From: Christina Wollman
Sent: Monday, December 30, 2013 3:13 PM
To: Jeff Watson; Lindsey Ozbolt
Cc: Mark Wenger (MWenger@talyst.com); Ginger Weiser (gweiser@encompasses.net); Marc Kirkpatrick (mkirkpatrick@encompasses.net)
Subject: RE: Kittitas County Notice of Application SP-07-00007 Wenger

Wenger Short Plat SP-07-00007

WENGER SHORT PLAT

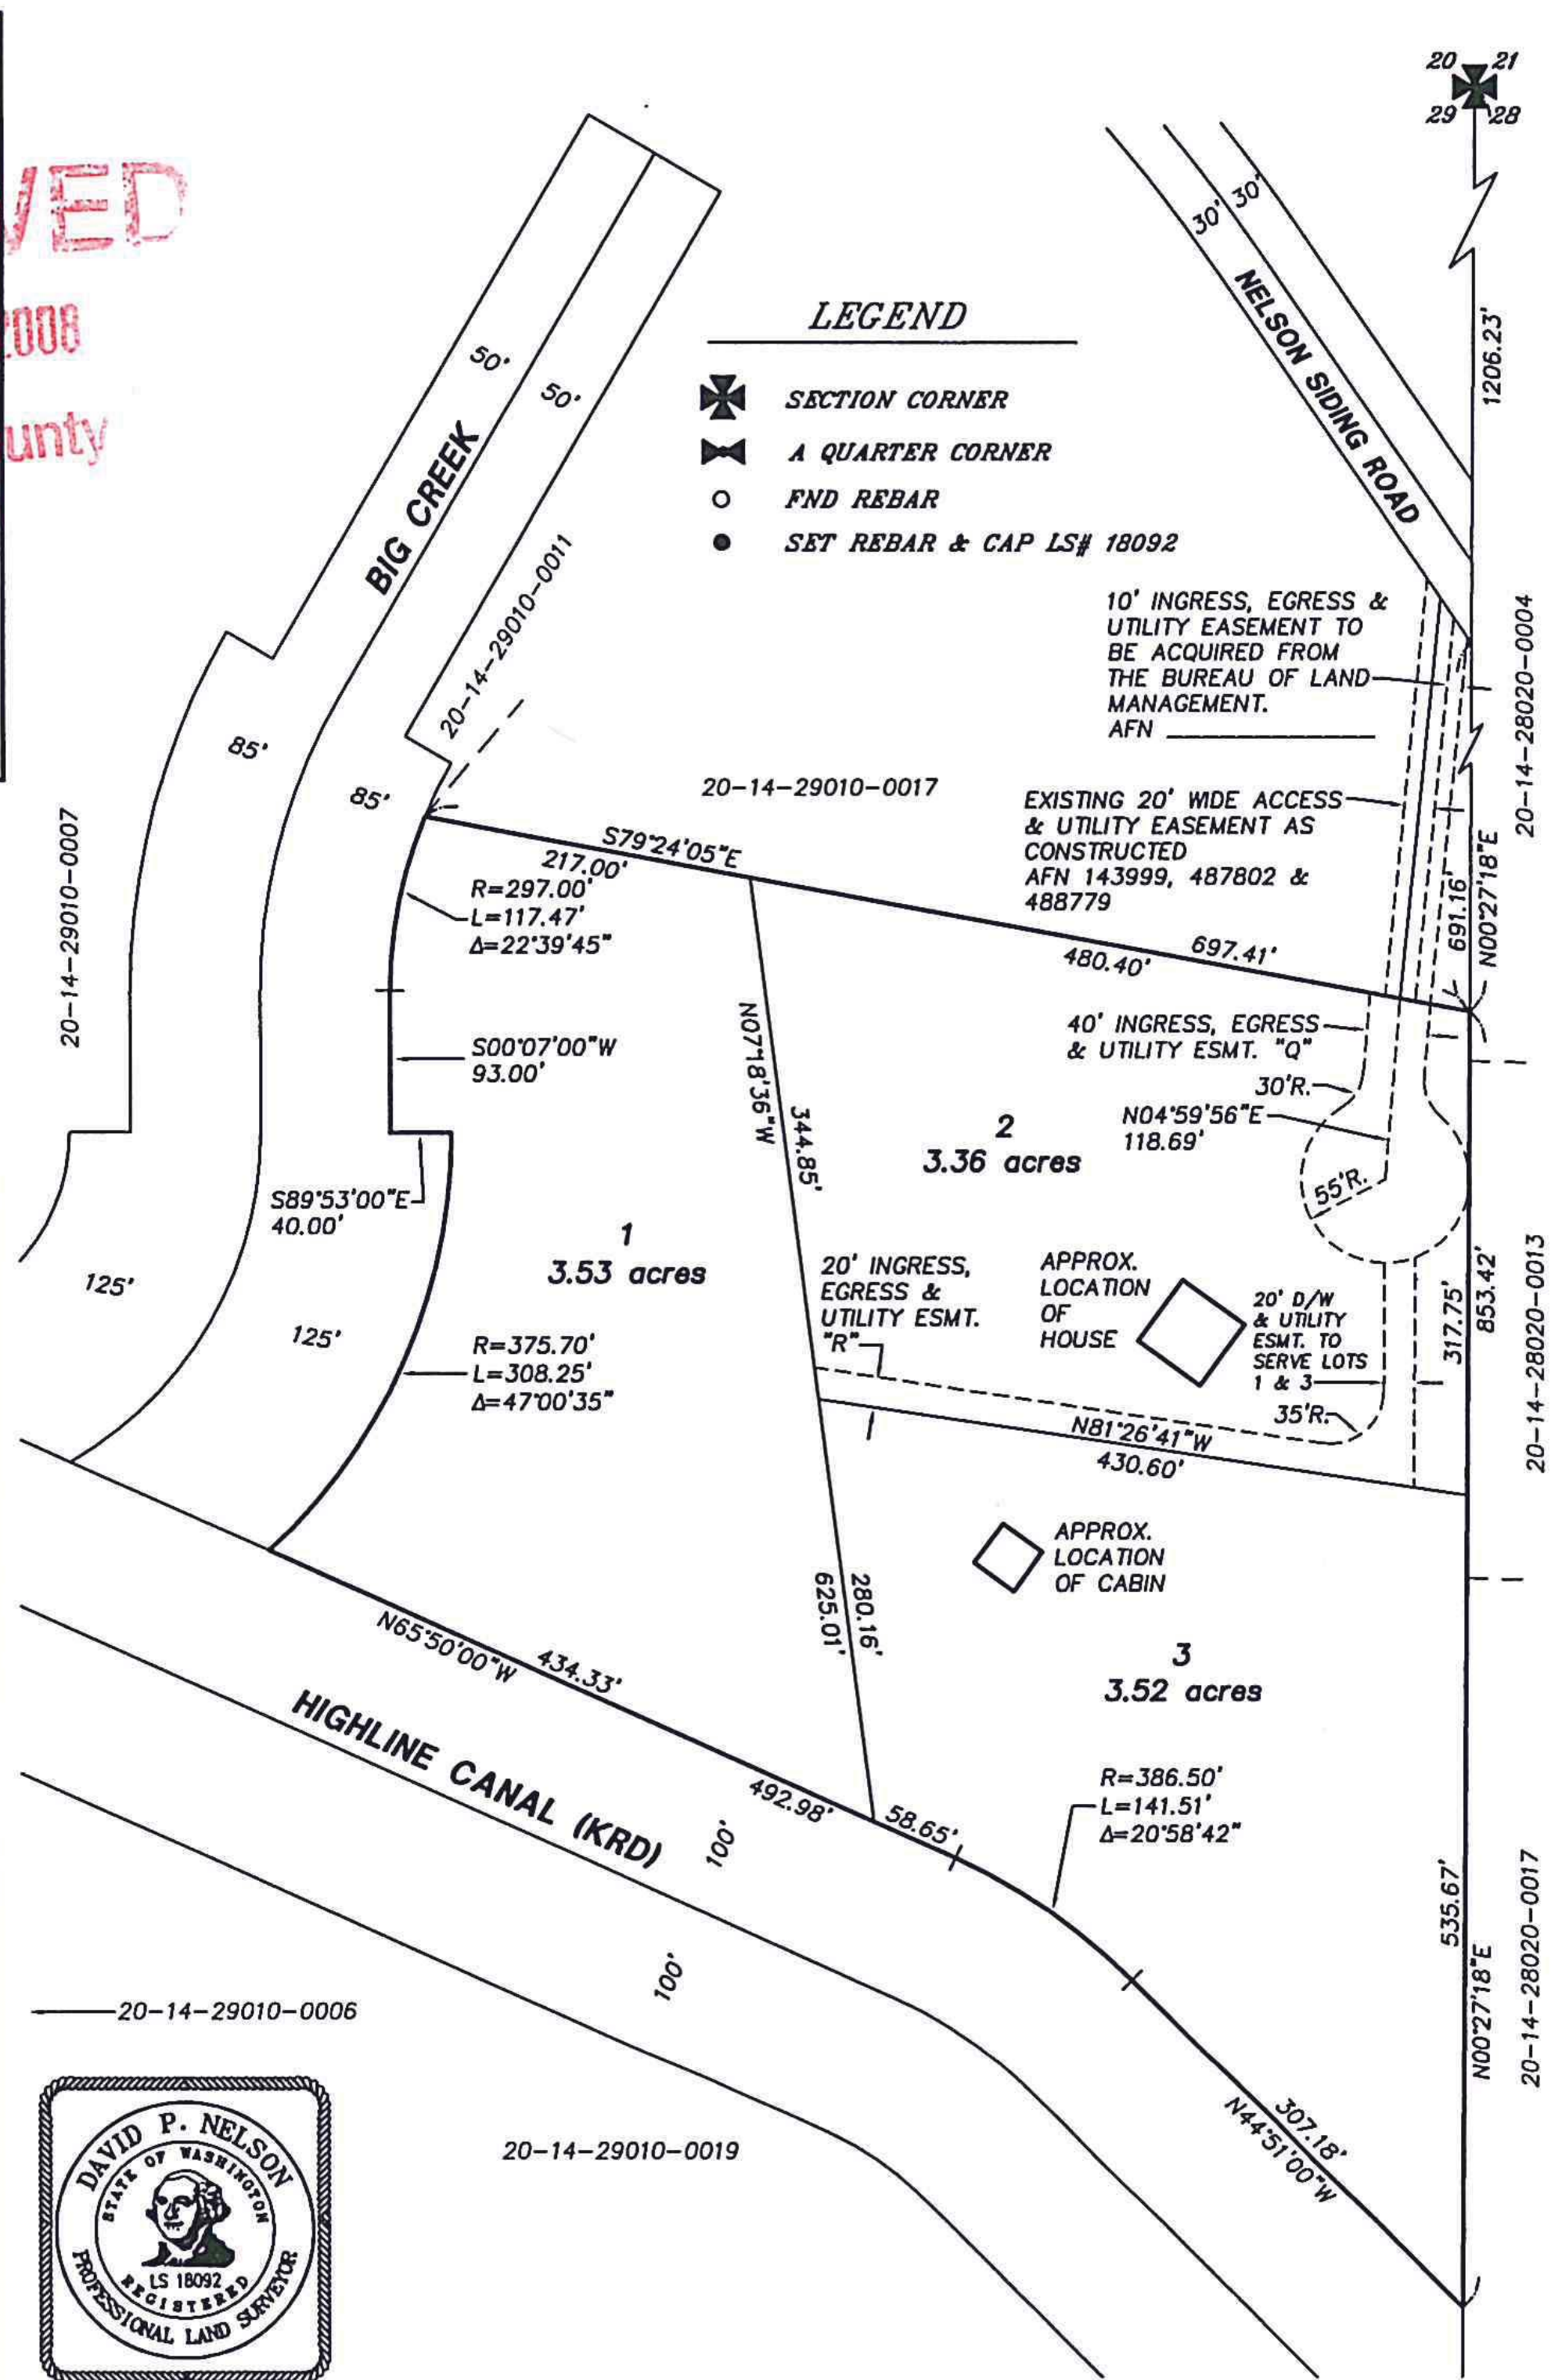
Jeff, in order to properly review this project for flood impacts, I need the 100-year floodplain drawn on the short plat. I need to ensure that there is a buildable area outside of the 100-year floodplain on all parcels. This will prevent the landowner from needing to hire a hydraulic engineer to do a study. Unfortunately the parcels lines and floodplain boundaries on our maps are not accurate enough to make a visual determination.

For review purposes, the 200' shoreline jurisdiction should also be included on the short plat. The location of Big Creek should be shown for reference.

And, it's hard to tell through the trees where the driveway is for 4686 Nelson Siding Road, which crosses the subject property. I need to know the location of the driveway as well.
